EIS – COMMENTS FOR CONSIDERATION – 15 BOB IRVIN ROAD, YOOGALI

Drawing Title		
GRIFFITH BESS HEAVY VEHICLE SITE ACCESS SWEPT PATH ANALYSIS		
Designed DA	Approved VG	Metway Ref NA
Project Number 250170	Drawing Number SPA101	Revision A

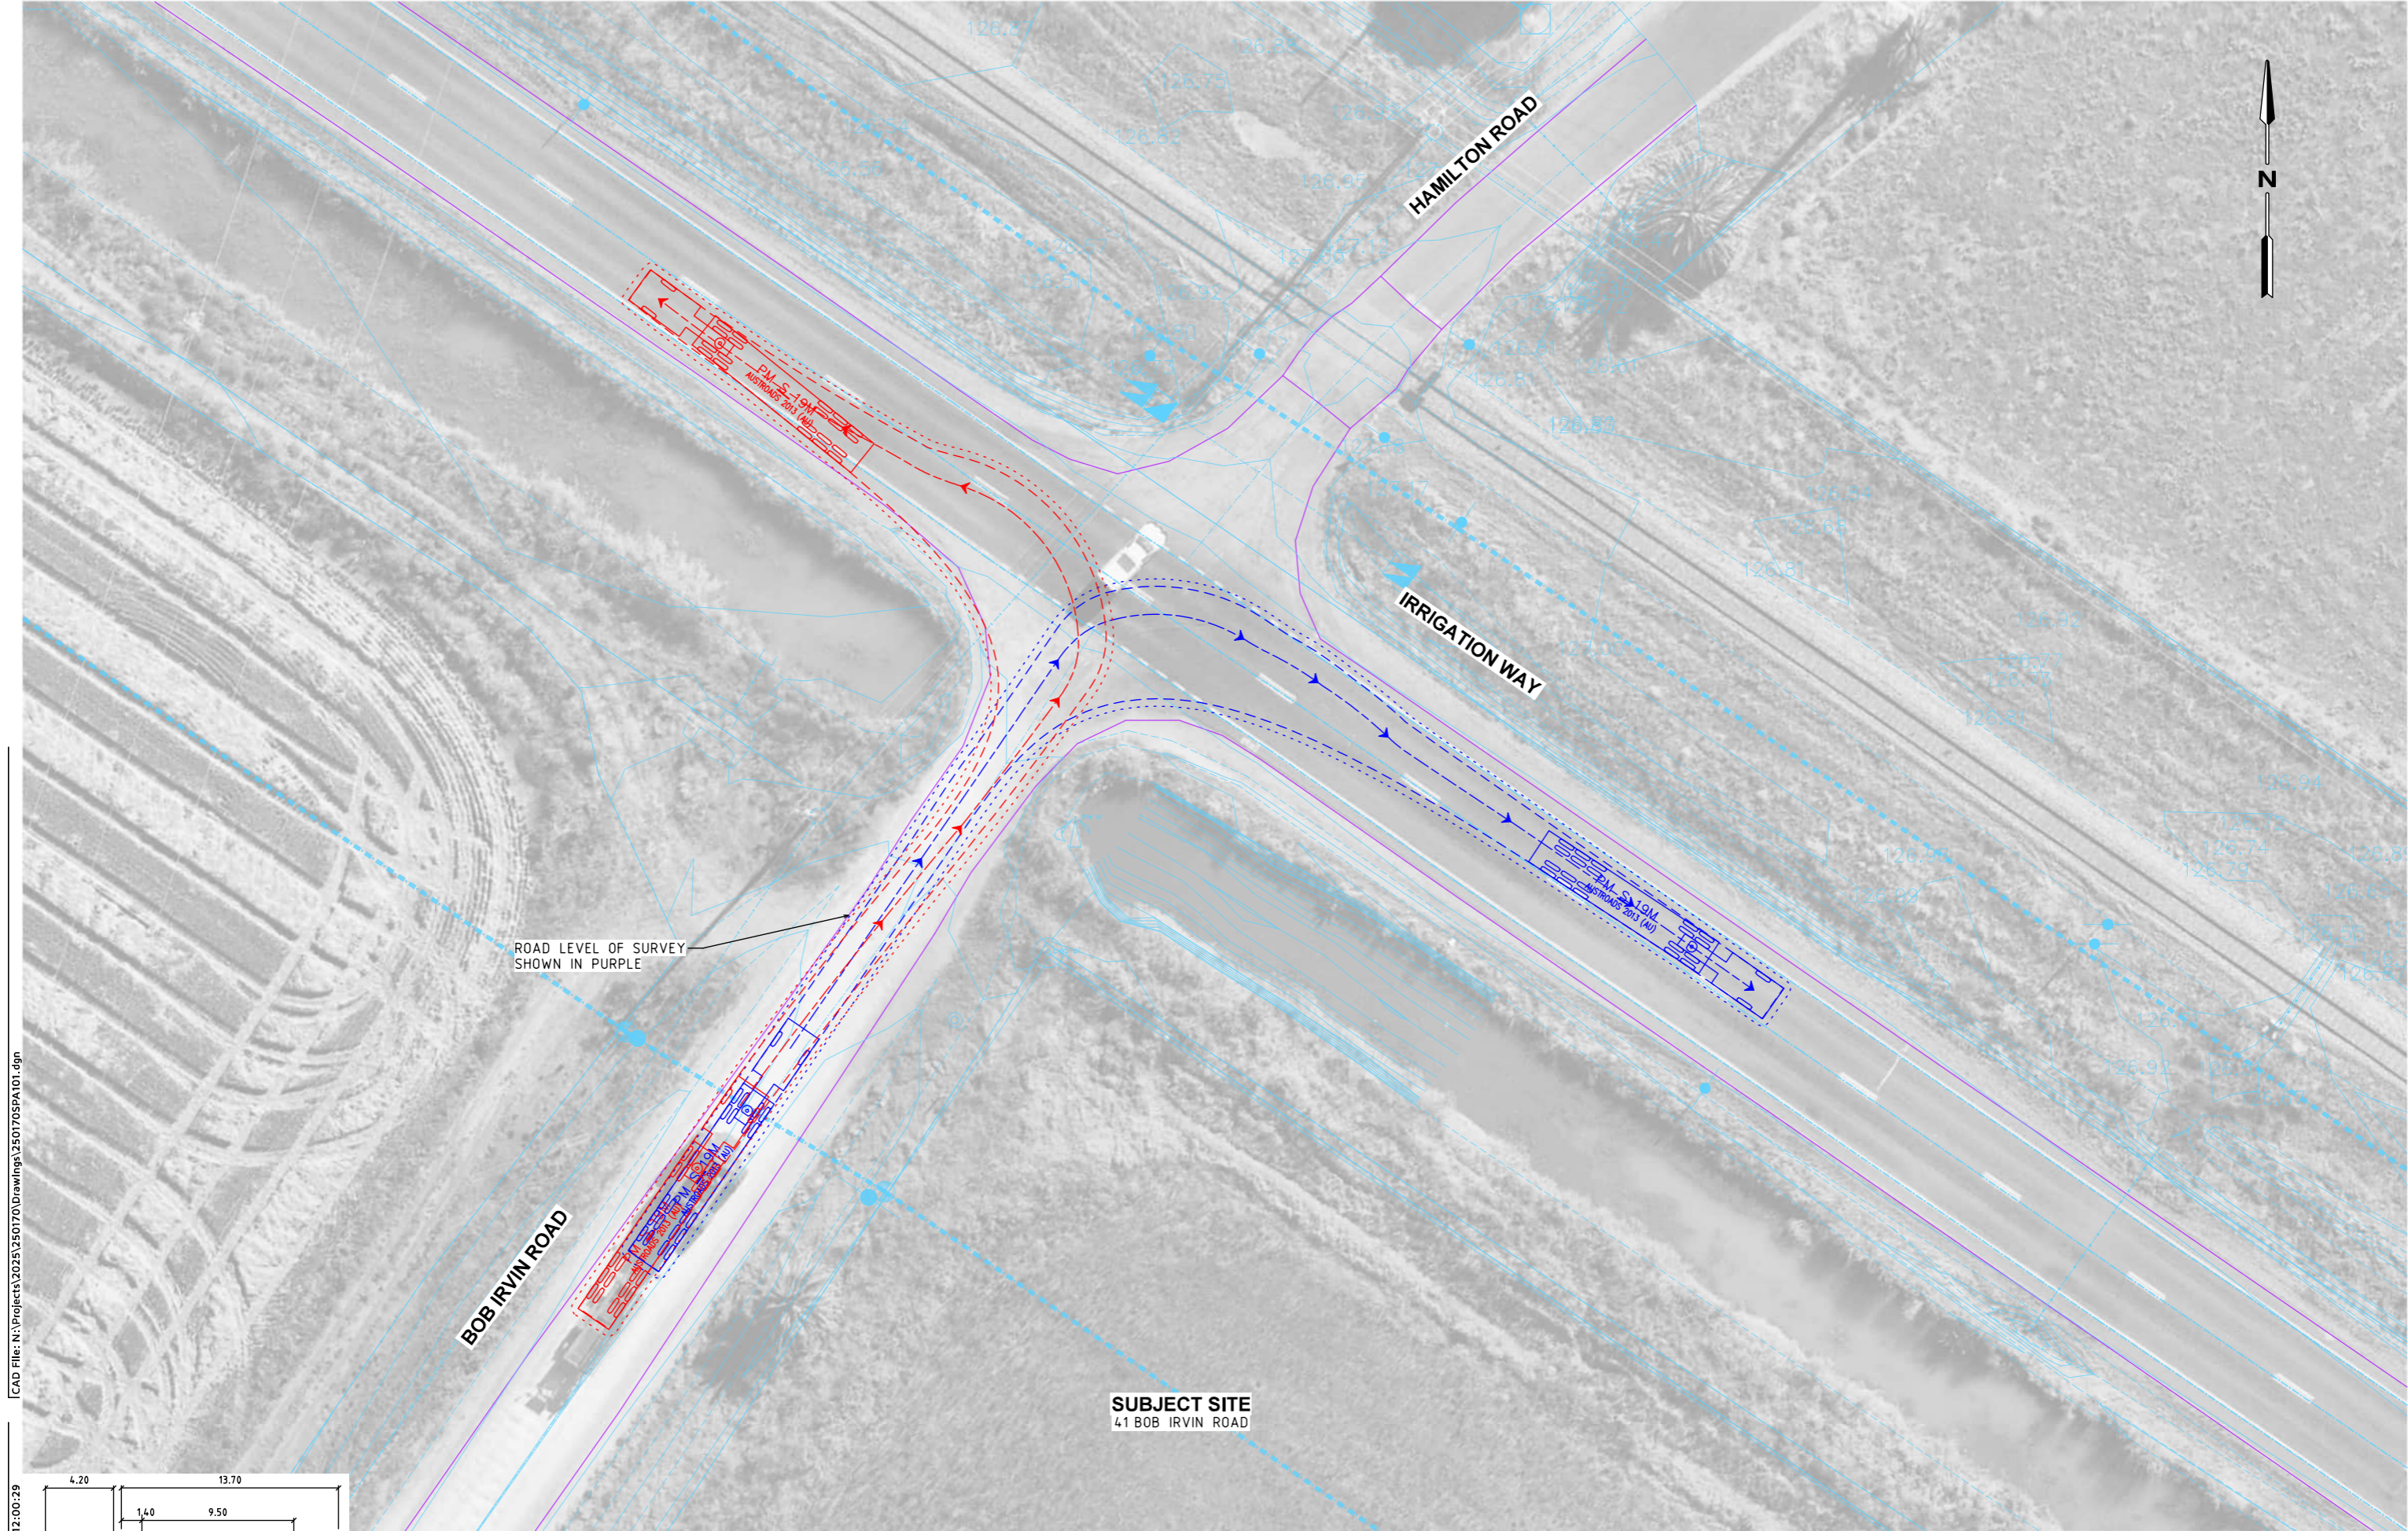
- It is noted at 7.2 in the submitted Traffic Impact Assessment (**onemilegrid** – 12 November 2025) that *19 metre semi-trailers can turn into and out of Bob Irvin Road using the existing road width* – however turning path diagrams within that assessment document show a 19 metre semi-trailer turning left out of Bob Irvin Road encroaching into the opposing travel lane of Irrigation Way (100km/h zone.) In furtherance, the swept paths show heavy vehicles turning left from Irrigation Way into Bob Irvin Road do so by encroaching into the opposing travel lane and leave the western shoulder of the road potentially onto the batter associated with the irrigation channel. When reviewing previous development application (291/2018) it was a condition of consent (27) that the intersection of Irrigation Way and Bob Irvin Road be upgraded so as such encroachment into apposing travel lanes is mitigated.

Council's position is that condition shall remain – but based on the increase in traffic generation, a basic right turn treatment (BAR) be constructed on Irrigation Way at the intersection to allow through eastbound traffic on that road to pass (on the near side) vehicles turning right from Irrigation Way into Bob Irvin Road. **Note:** Any upgrades on Irrigation Way will be at the discretion of the road manager – Transport NSW.
